**WELWYN HATFIELD BOROUGH COUNCIL
EXECUTIVE DIRECTOR - PLANNING, PUBLIC PROTECTION AND GOVERNANCE**

DELEGATED APPLICATION

Application No: 6/2016/2504/HOUSE
Location: 7 Densley Close Welwyn Garden City AL8 7JX
Proposal: Enclosure of existing covered area to rear of property with installation of bi-folding doors
Officer: Mr A Mangham

6/2016/2504/HOUSE

Drawing No: 4025-P01 Revision: A

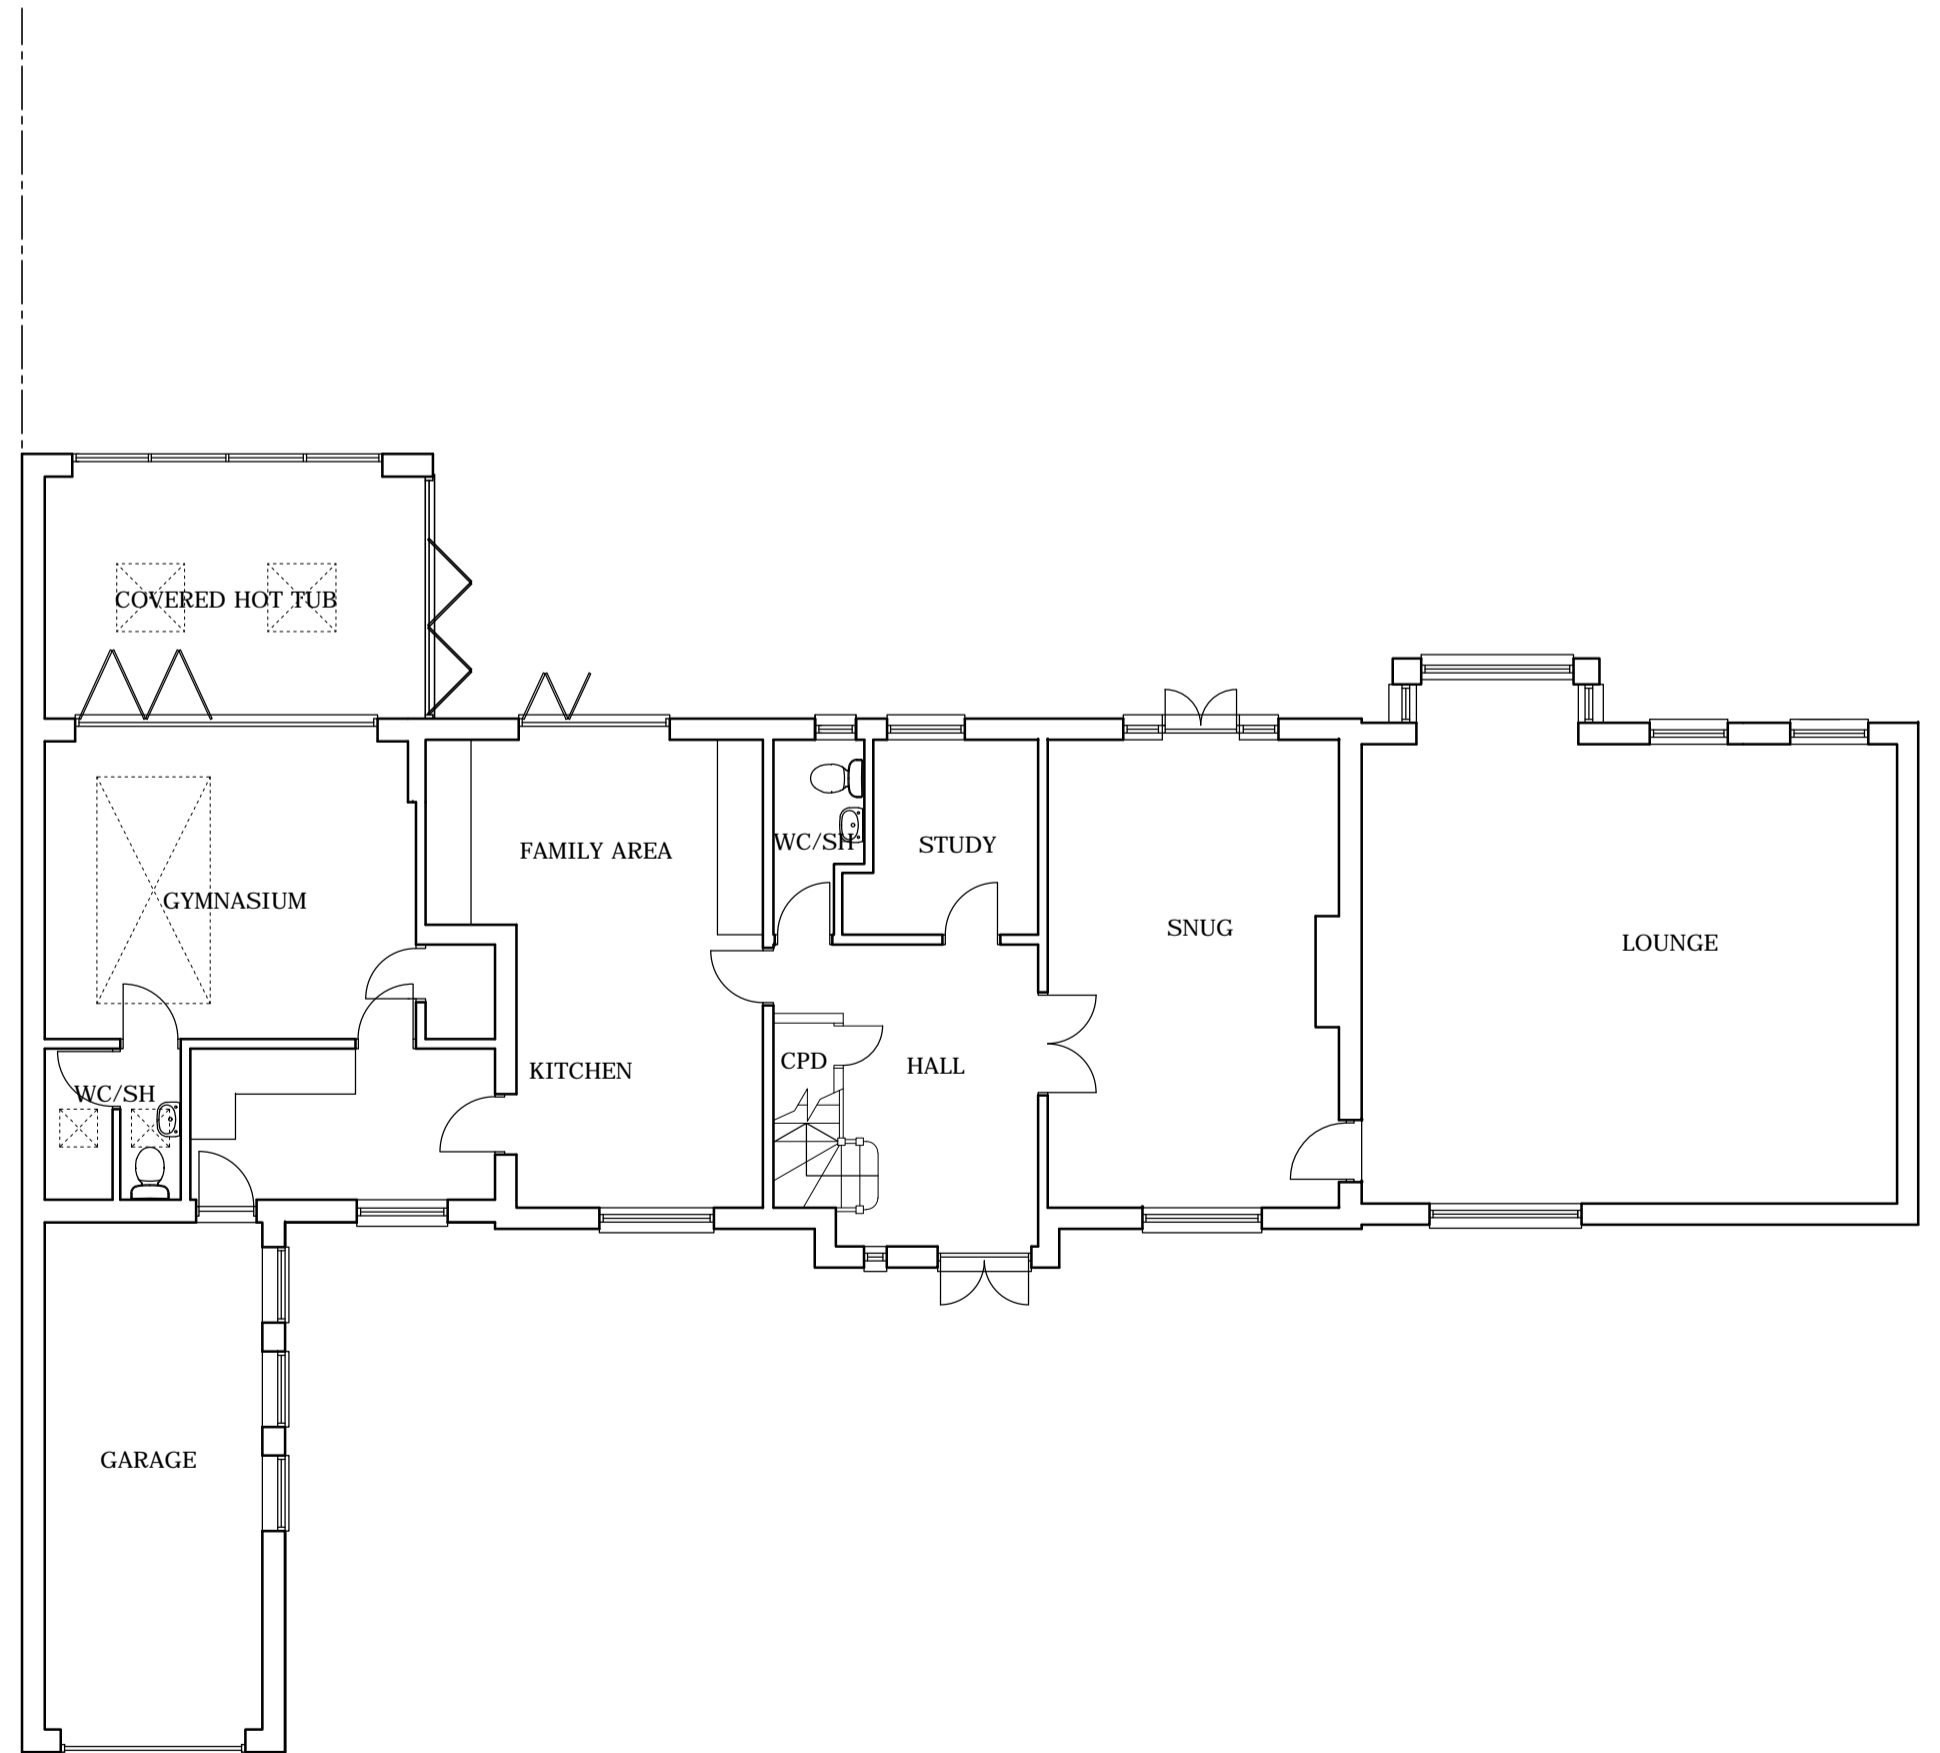
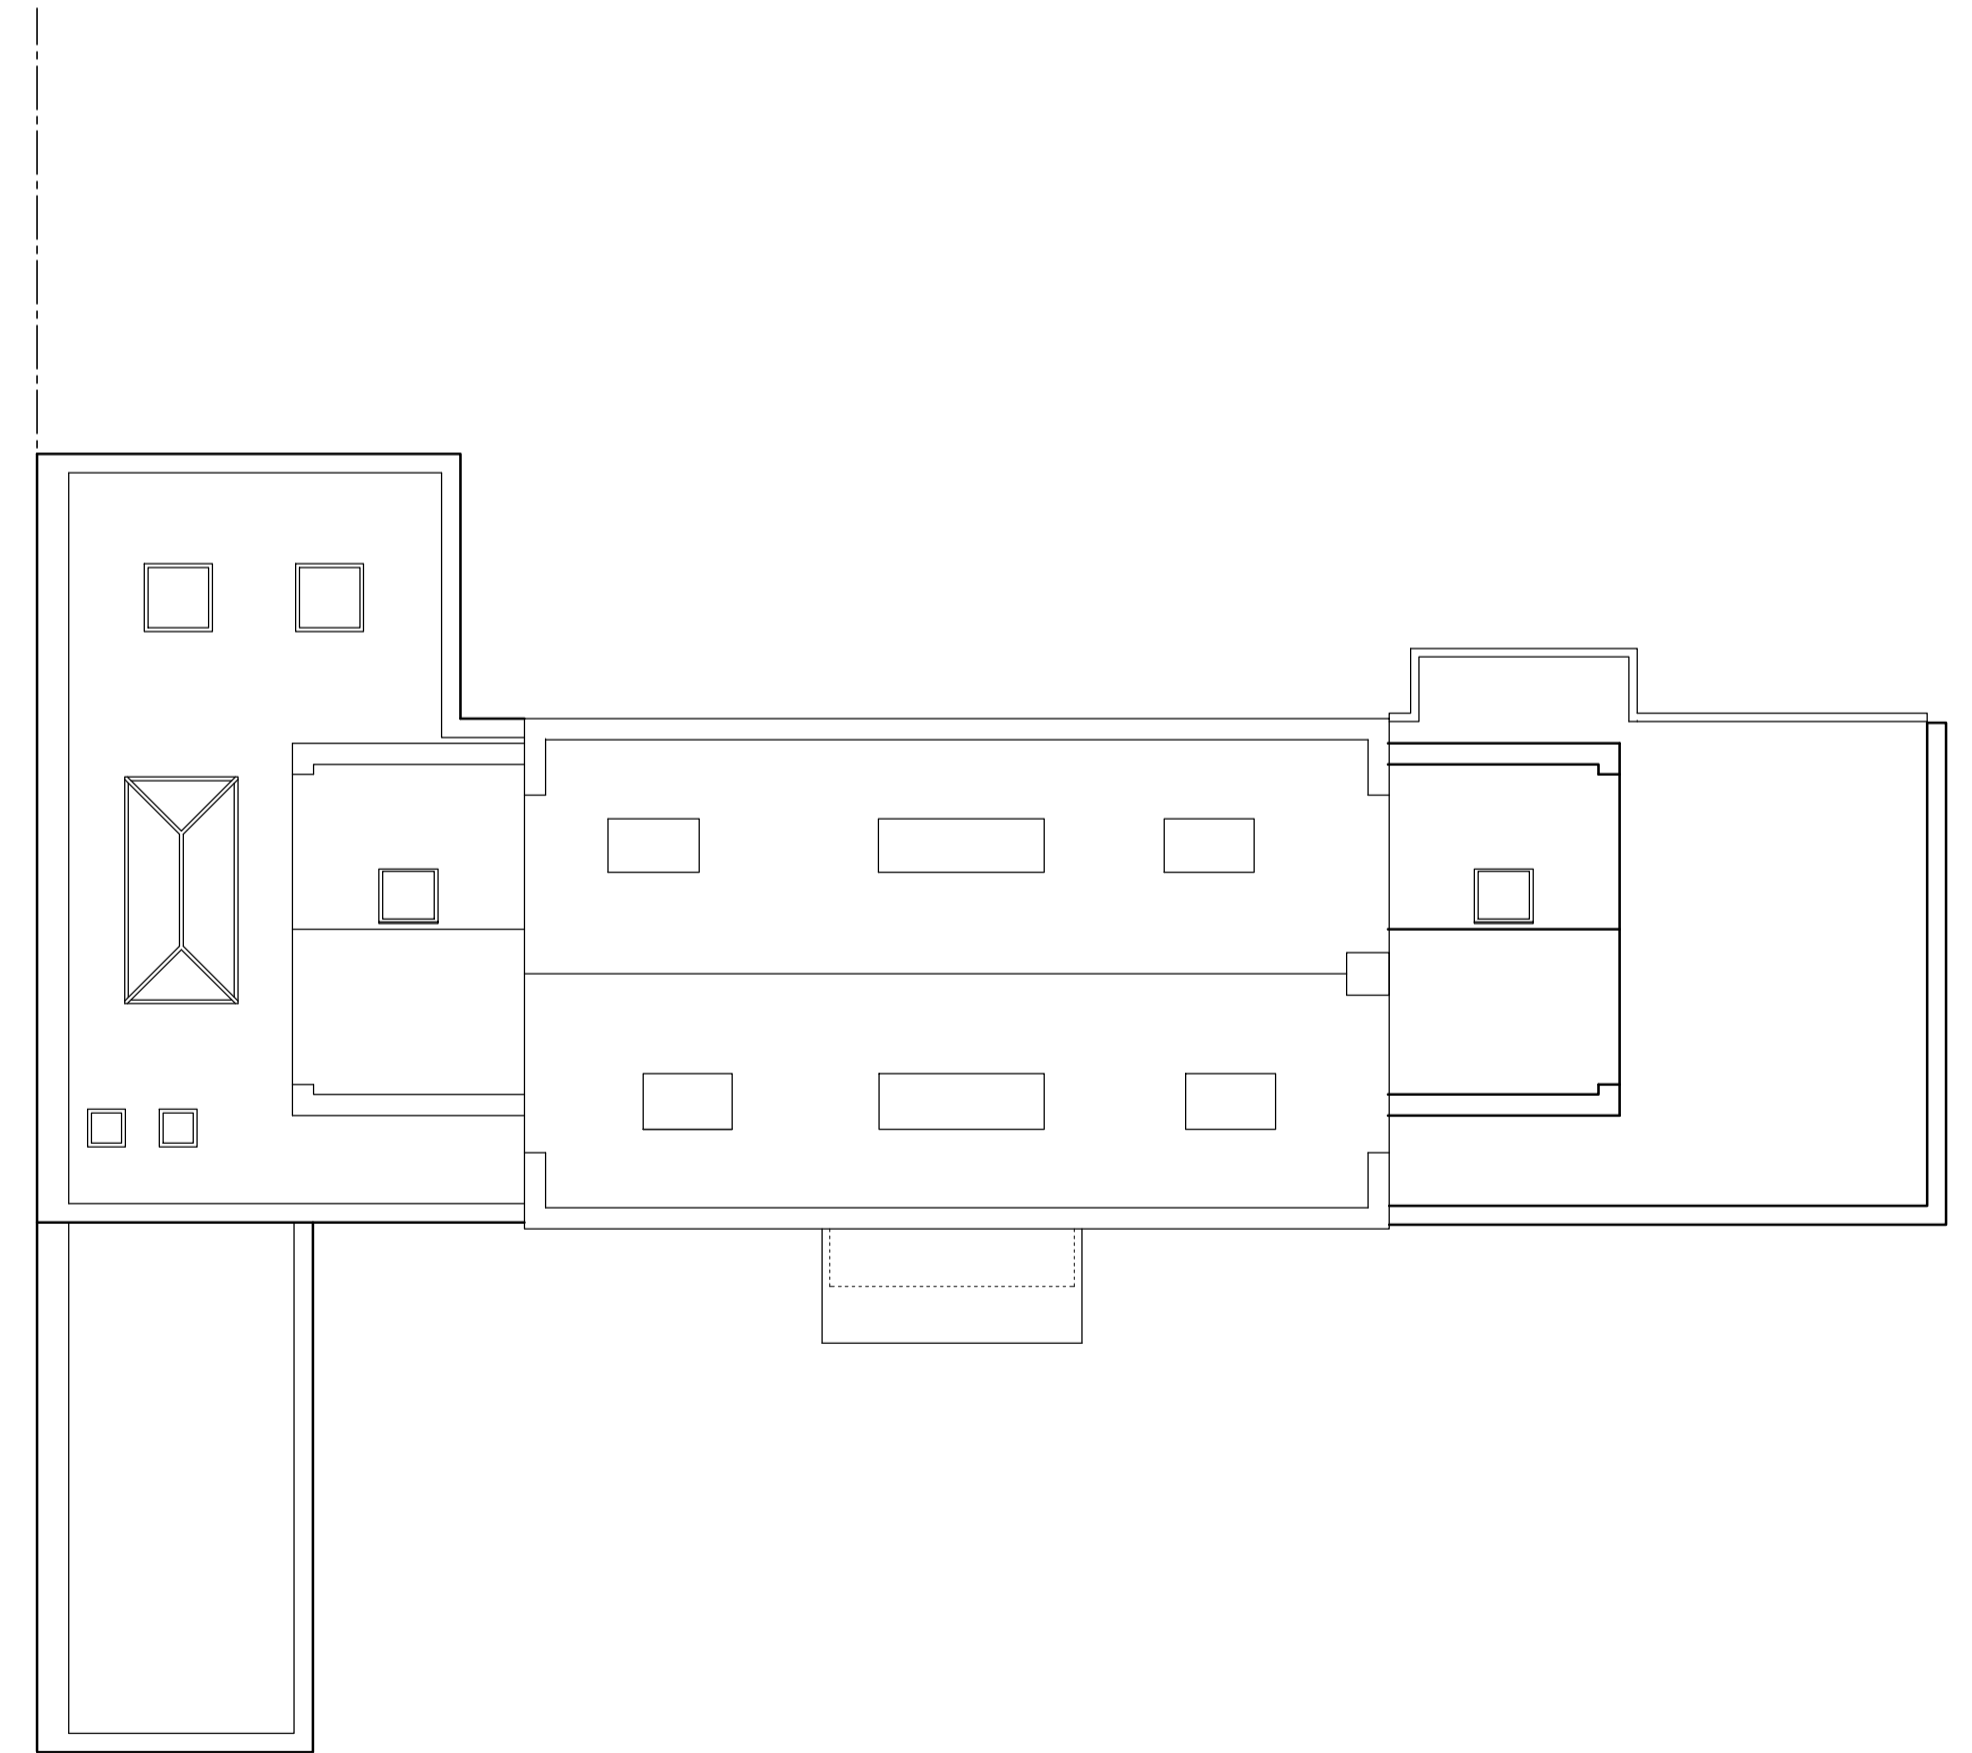
No. 19 Scholars Mews, a detached property, is located south of the host properties rear garden. The proposed bi-folding doors, and whilst facing the objector's rear two storey elevation, will result in a spacing distance of approximately 30 metres.

This spacing distance, whilst there will be a resultant visual relationship, is considered not to result in any significant degree of overlooking between the subject doors, including its use within, and the rear elevation of the objectors property that would be considered detrimental to the extent to warrant a refusal on the detrimental impact on living conditions. In these circumstances, it is also considered that a condition to impose obscure glazing, or indeed non-opening windows, is also unjustified by virtue of the quoted extensive spacing relationship.

In light of the above, the proposed development would on balance be acceptable in regards to Policies D1 and D2 of the Welwyn Hatfield District Plan 2005 as well as the Supplementary Design Guidance 2005
